Appeal NO: ABP -314485-22

SMTW Environmental DAC response to  
appeals

Case Number: **ABP-314485-22**

FCC Ref #: F20A/0668

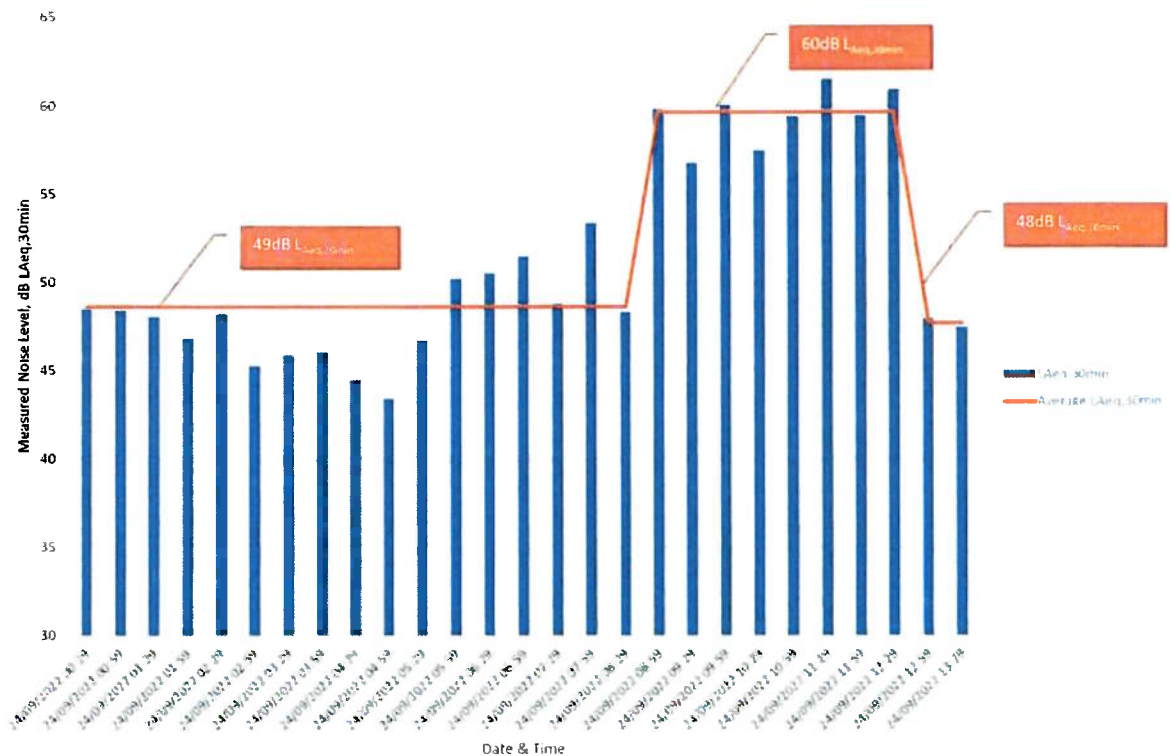
In relation to aircraft noise from the North Runway and its effects on children, a technical note was prepared by Dr Eoin King from NUI Galway (Appendix A). In the assessment, Dr King noted that the LAeq16 results were in excess of 60dB at a playschool directly under a flight path from the North Runway. This playschool (Tippy Toes) was not included in any insulation programme by the daa. Condition 6 of the North Runway's planning conditions state that the scheme shall include all schools and registered pre-schools predicted to fall within the contour of 60dB LAeq16 within twelve months of the opening of the runway:

Individual LAm<sub>ax</sub> results varied from 73dB to 84dB. Tippy Toes playschool is approximately 4.7km from the end of the North Runway. It is very evident that the insulation scheme for schools and playschools approved by Fingal County Council used incorrect modelled contours. An Bord Pleanála needs to invalidate the current insulation scheme and ensure that a correct scheme is put in place. It is very evident that the insulation scheme was modelled using straight out flight routes which are not compliant with current North Runway operations.

**Figure 4:** Flight Paths from North Runway – it is noted that Tippy-Toes Playschool and Afterschool is now directly underneath a flight path.

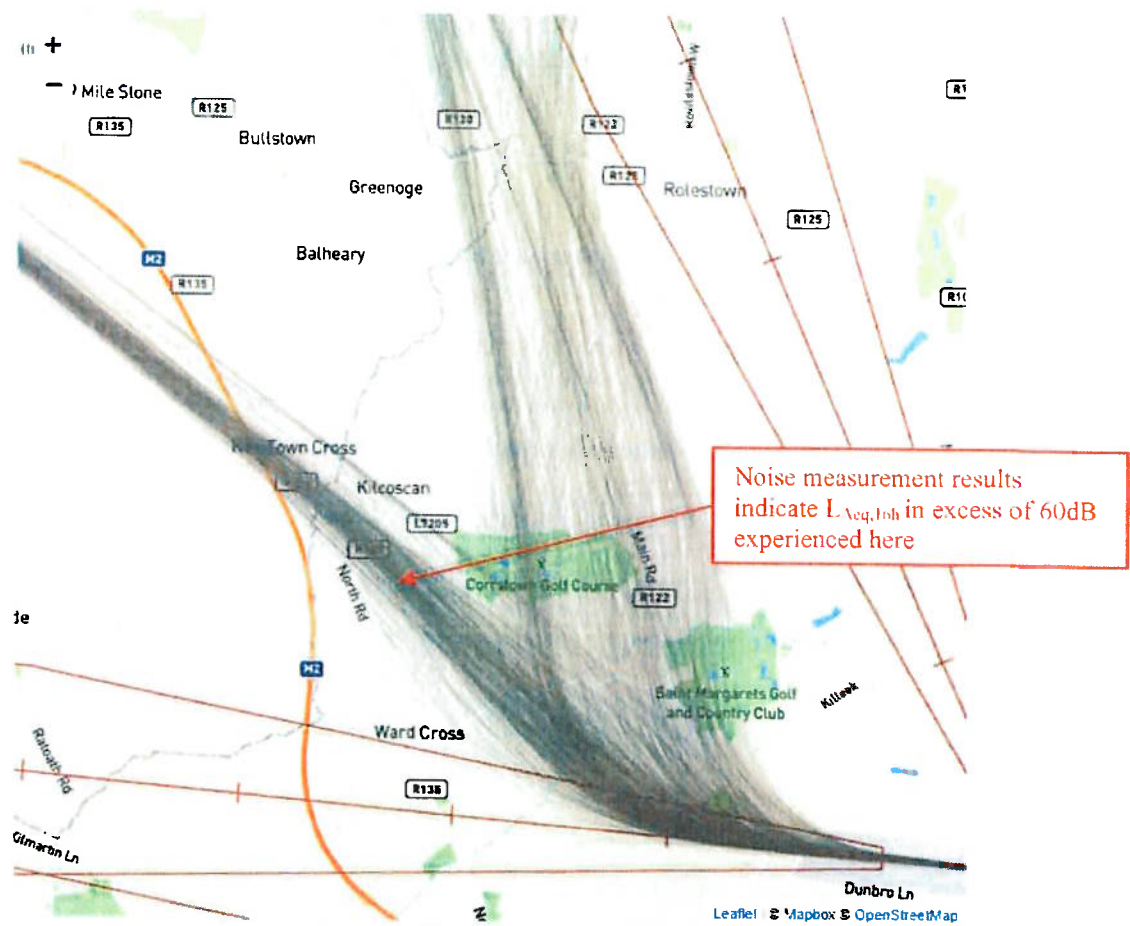
The contours for the noise insulation scheme were modelled by BAP using straight out flight paths. As a result, both Tippy Toes and Kilcoskan NS were excluded from the scheme as they were outside the 60dB LAeq16 contours modelled with straight out flight paths.
